**KIRKLEES METROPOLITAN COUNCIL  
INVESTMENT & REGENERATION SERVICE**

**DELEGATED DECISION TO DETERMINE PLANNING APPLICATIONS**

Reference No:	<b>2025/62/92729/W</b>
Site Address:	5, Sycamore Close, Lepton, Huddersfield, HD8 0EP
Description:	Erection of two storey extension to side, including dormers within front and rear roofslopes, application of render to side and rear, creation of additional parking to front and associated works
Recommending Officer:	Morgan Braithwaite

## OFFICER REPORT

NUMBER
22-002

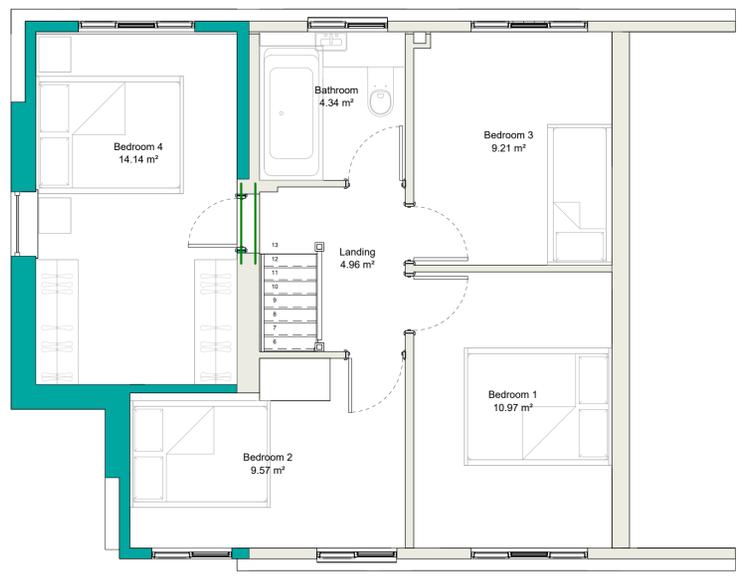
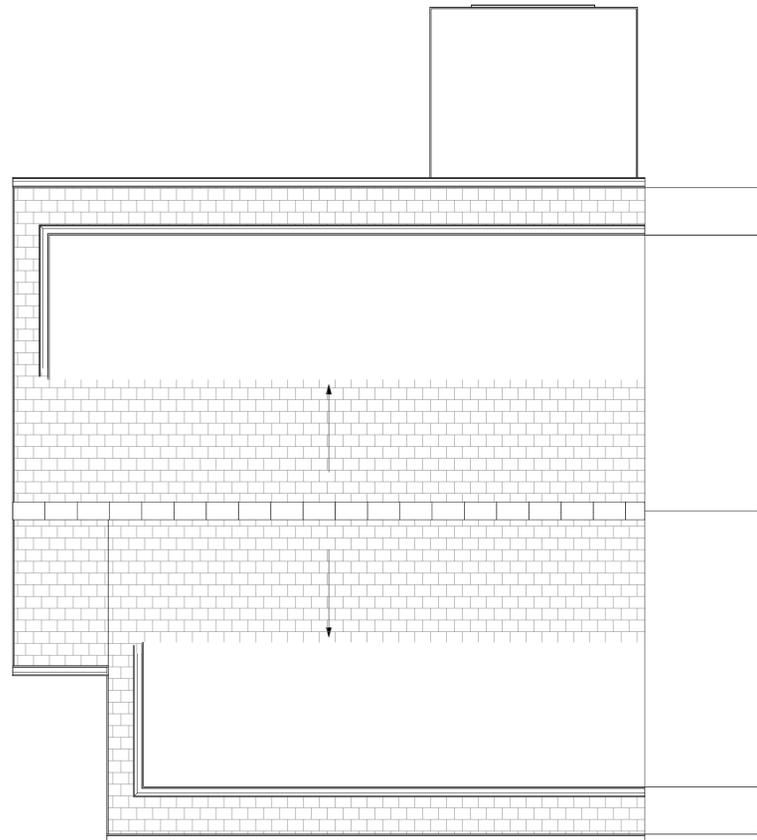
Amendments to the submitted plans were requested due to the initial proposal not complying with the SPD in term of highway safety. The initial proposal increased the number of bedrooms to four, however the required three parking spaces could not be provided, therefore it was requested that the plans were amended either to provide three parking spaces or retain the three existing bedrooms.

A Kirklees Council Highways Officer was consulted regarding the proposal. They concluded that the project did not comply with the SPD nor did it support highway safety. It was requested that plans be amended to create sufficient parking provision or the property maintained its three bedrooms.

NUMBER
22-002

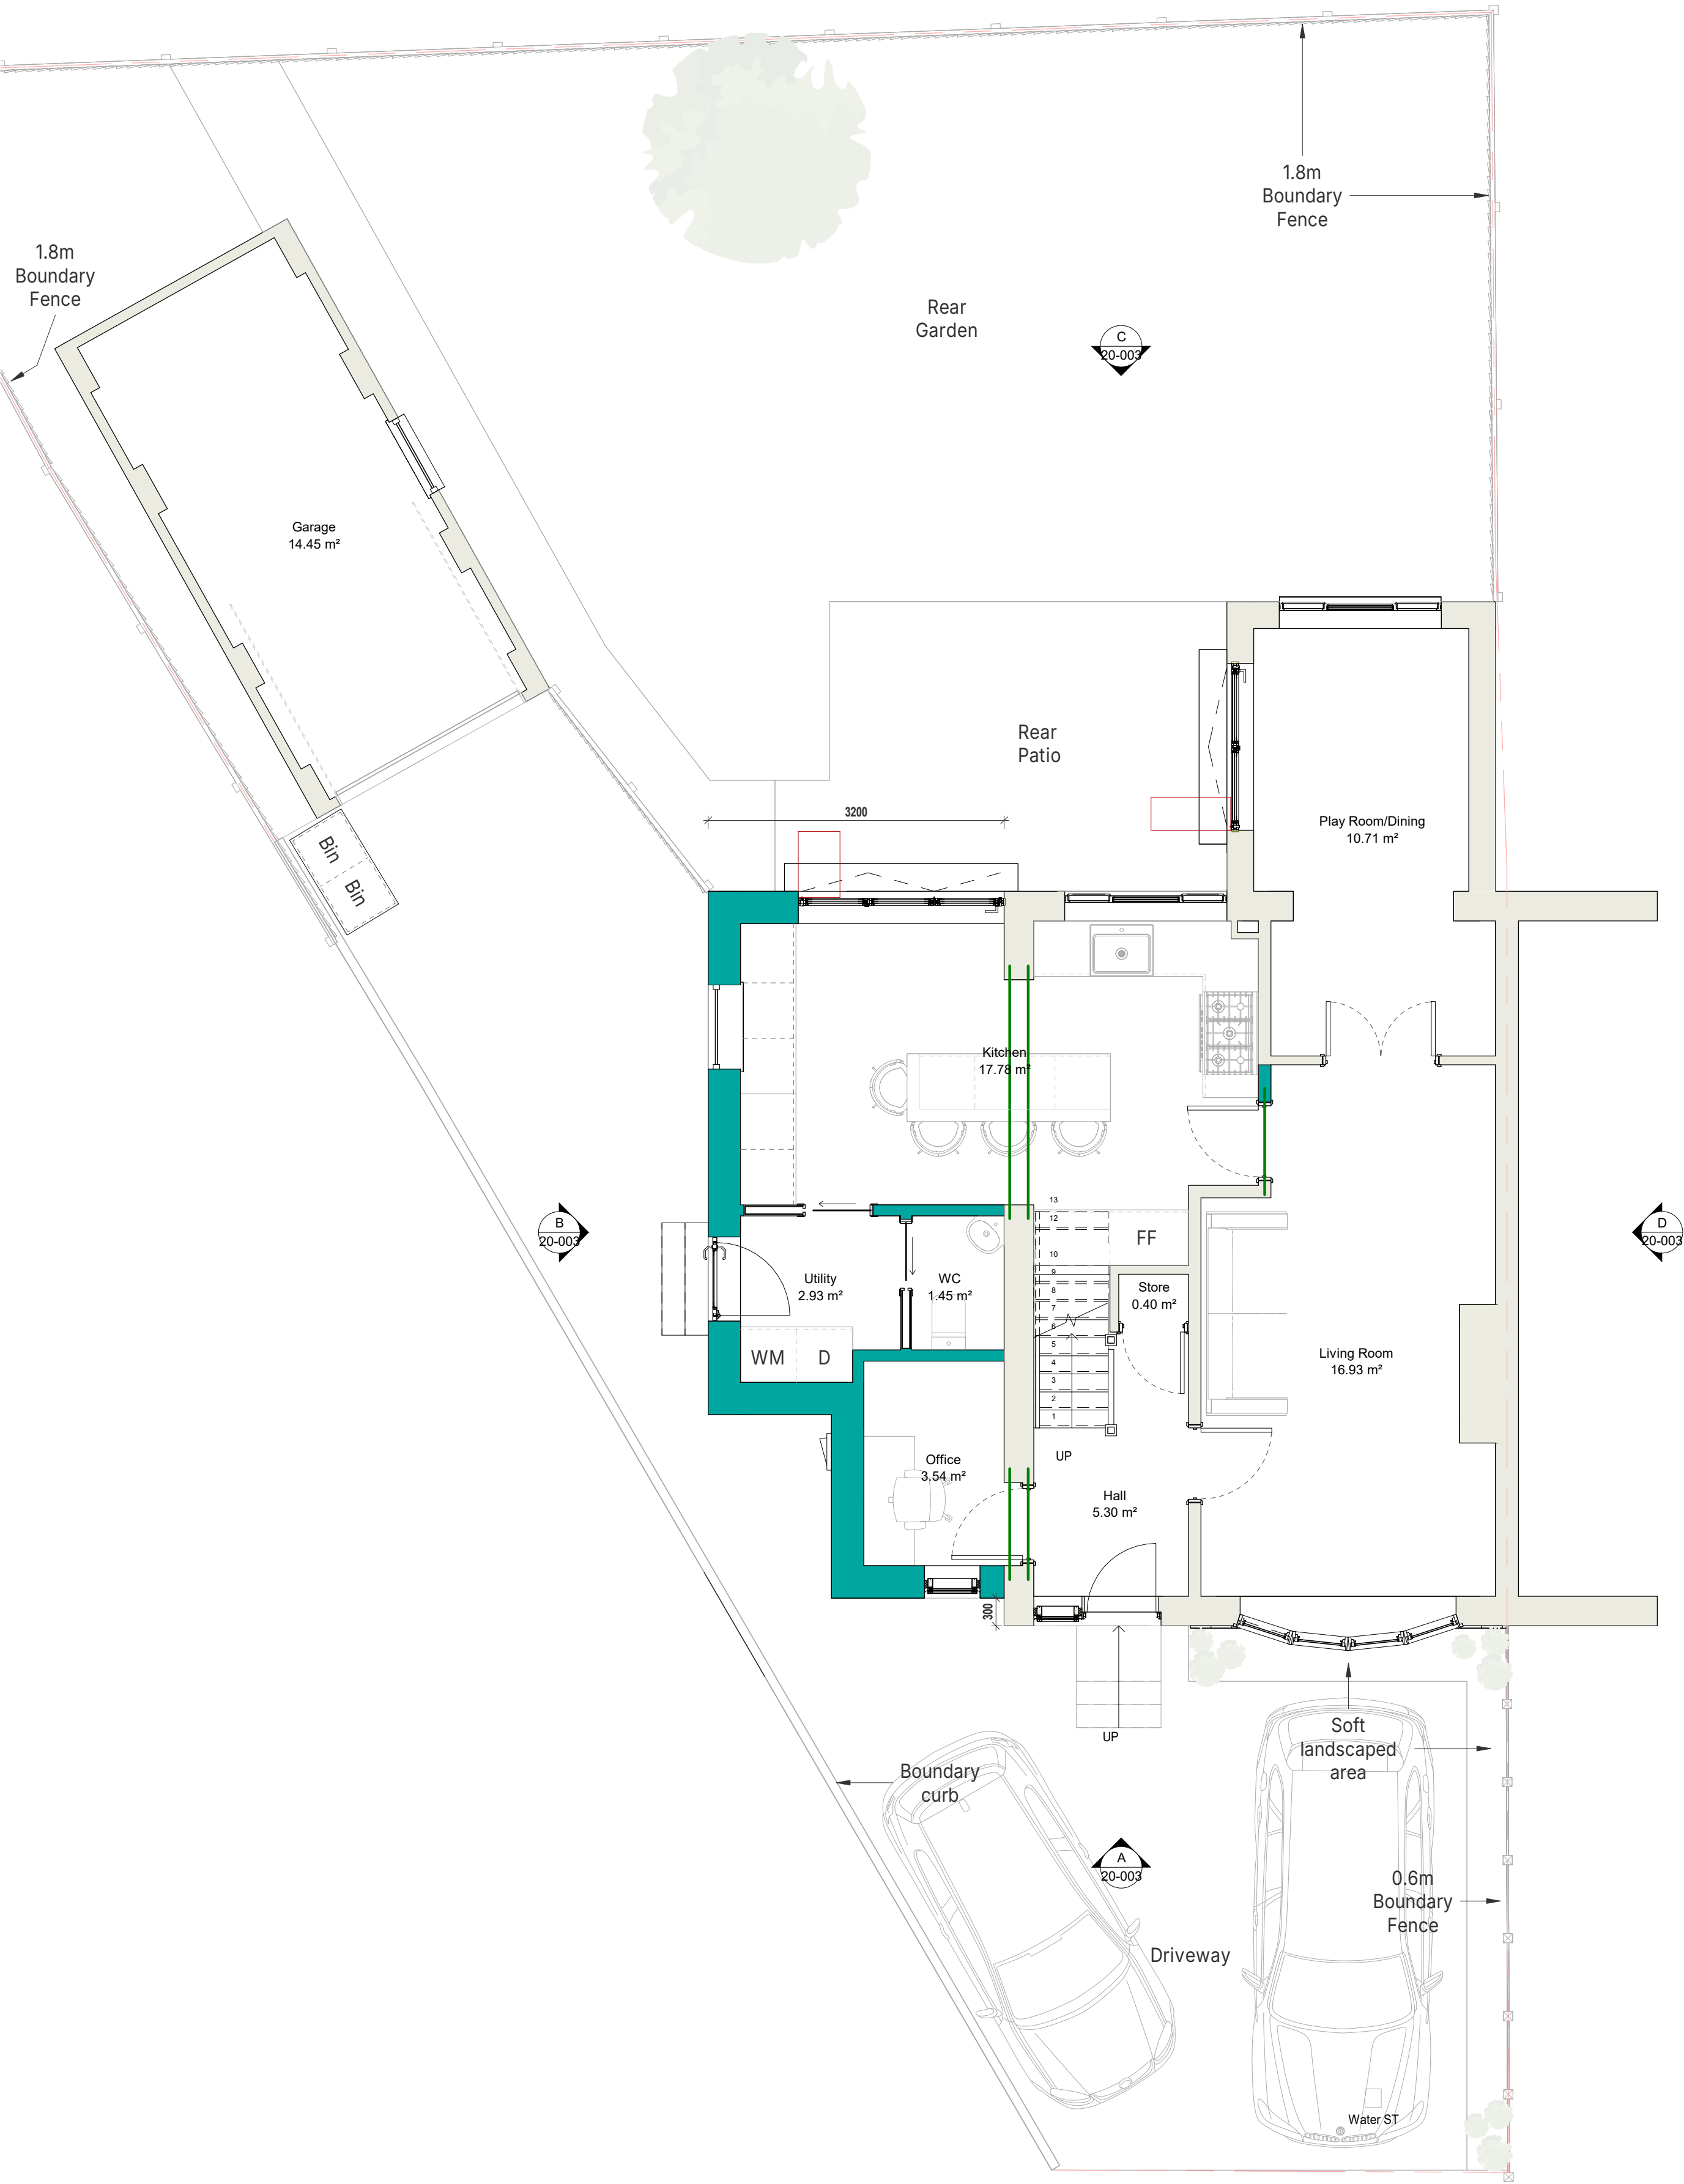
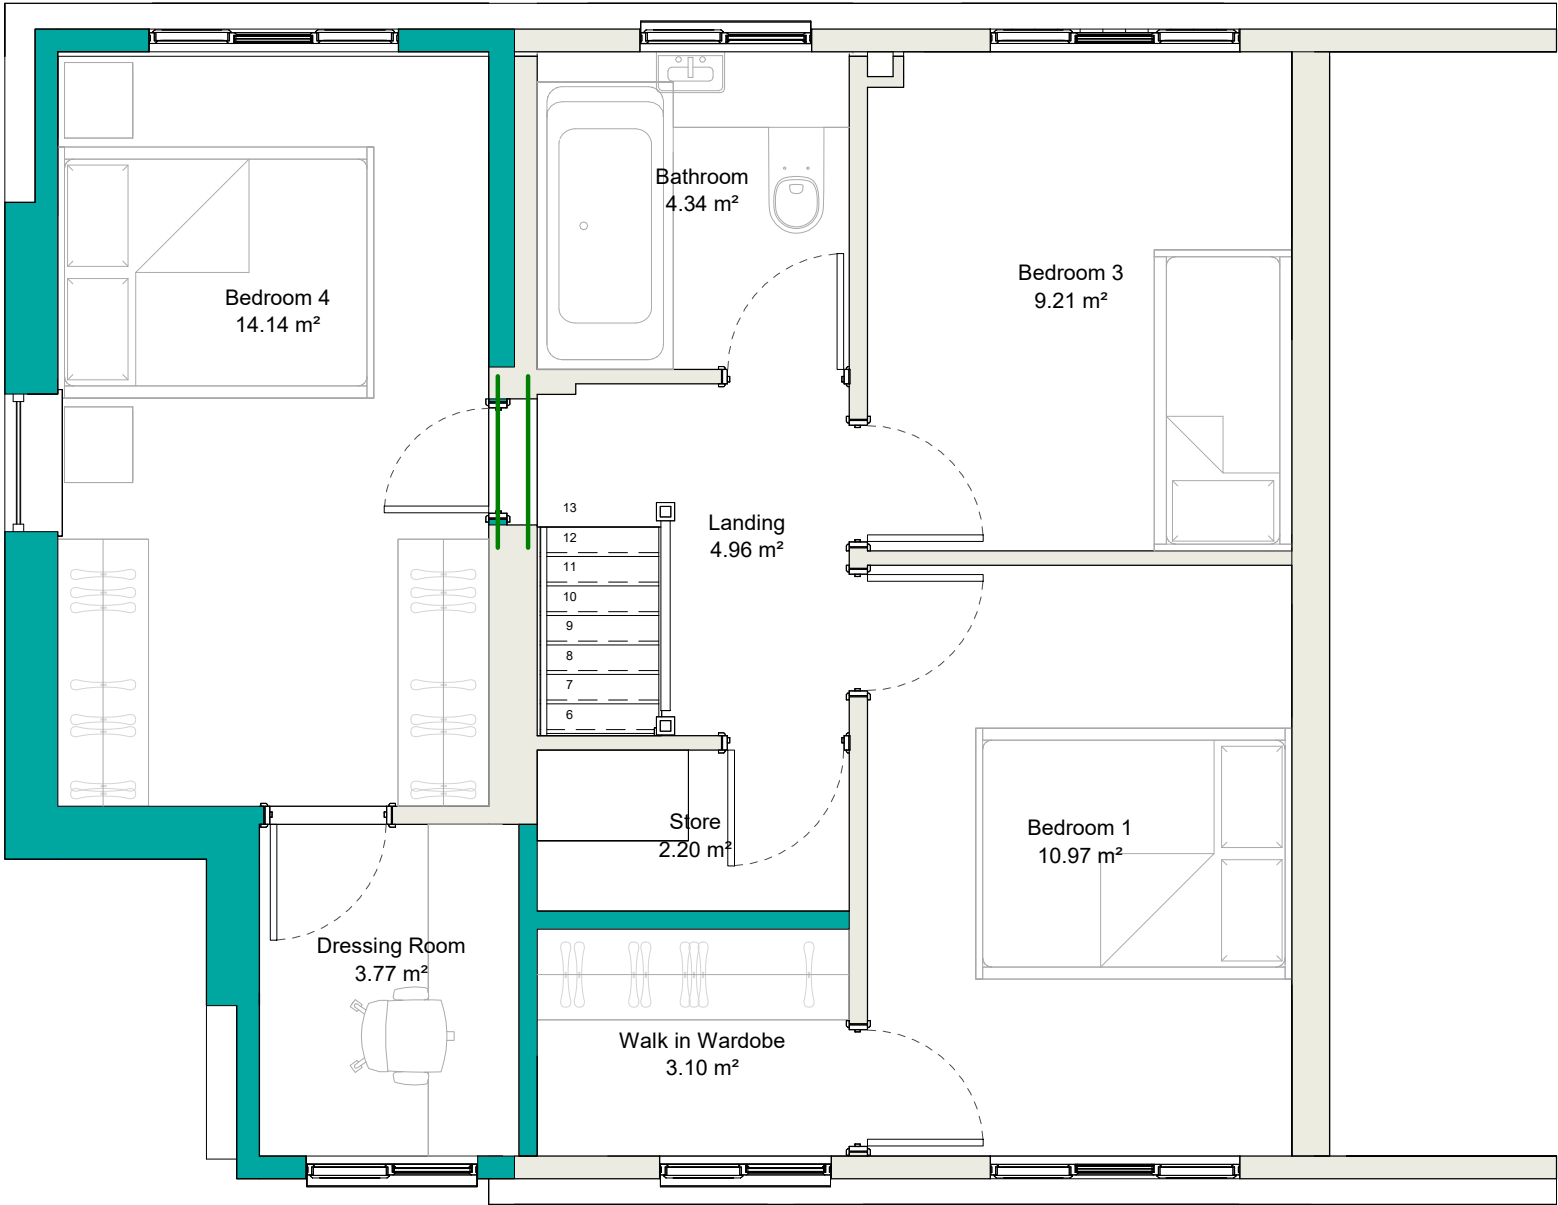
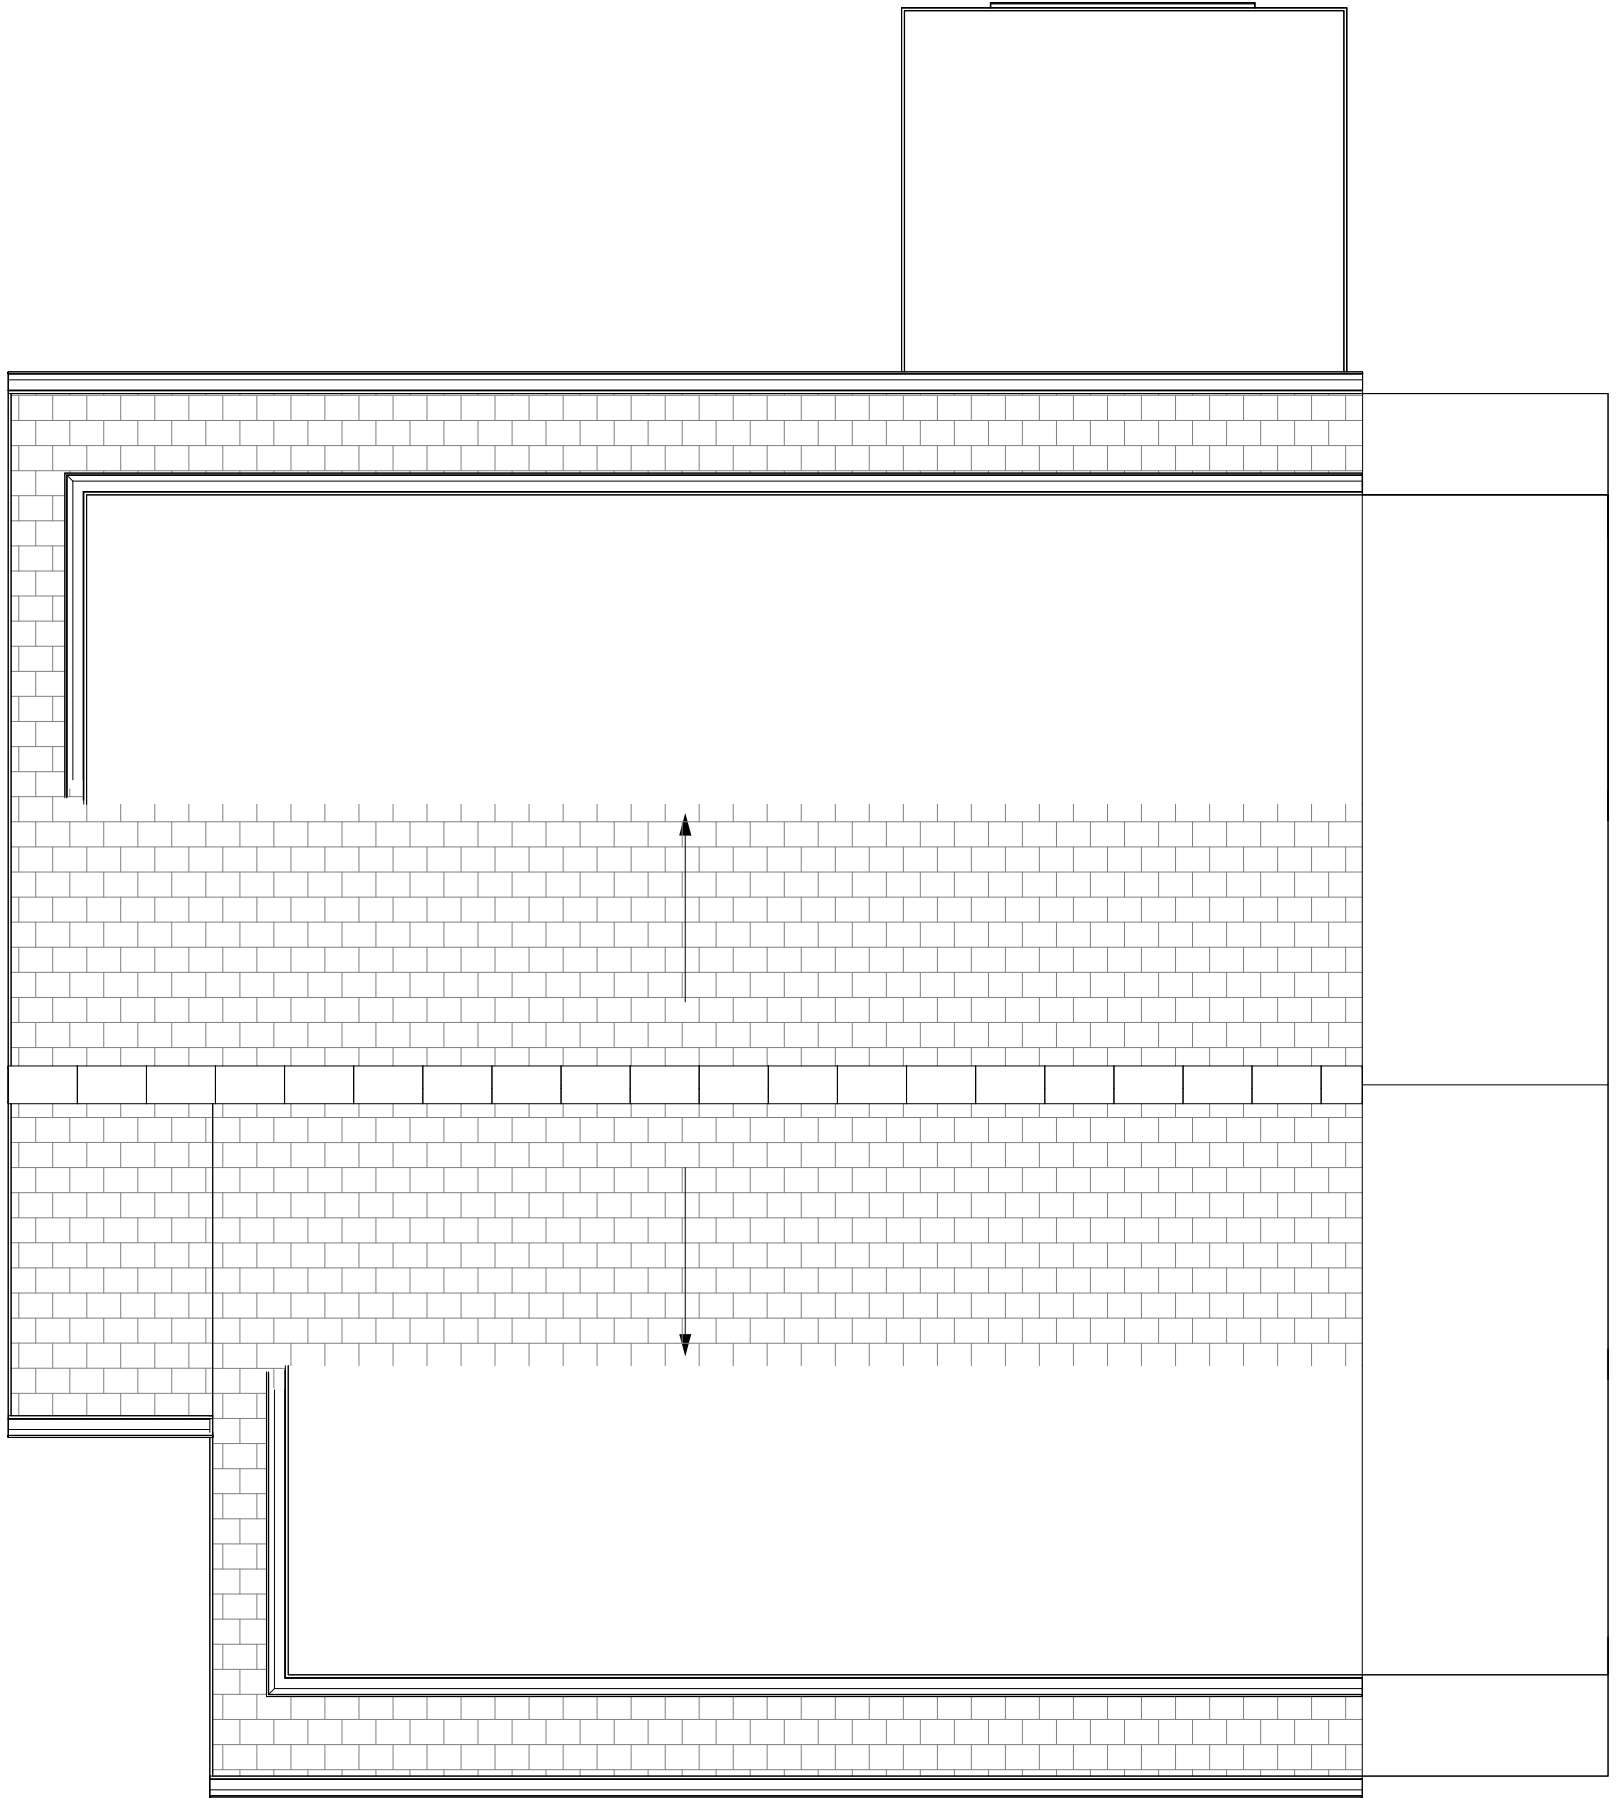
The proposal would result in some intensification of the domestic use of the property but would not increase the number of bedrooms. The proposal would result in the alteration and loss of parking provision along the driveway. However, sufficient parking provision is shown on plan 22-002 Rev A which is acceptable for a three bedroom property.

Plans were resubmitted indicating that three bedrooms were to be retained and two parking spaces to be provided to the front of the property.
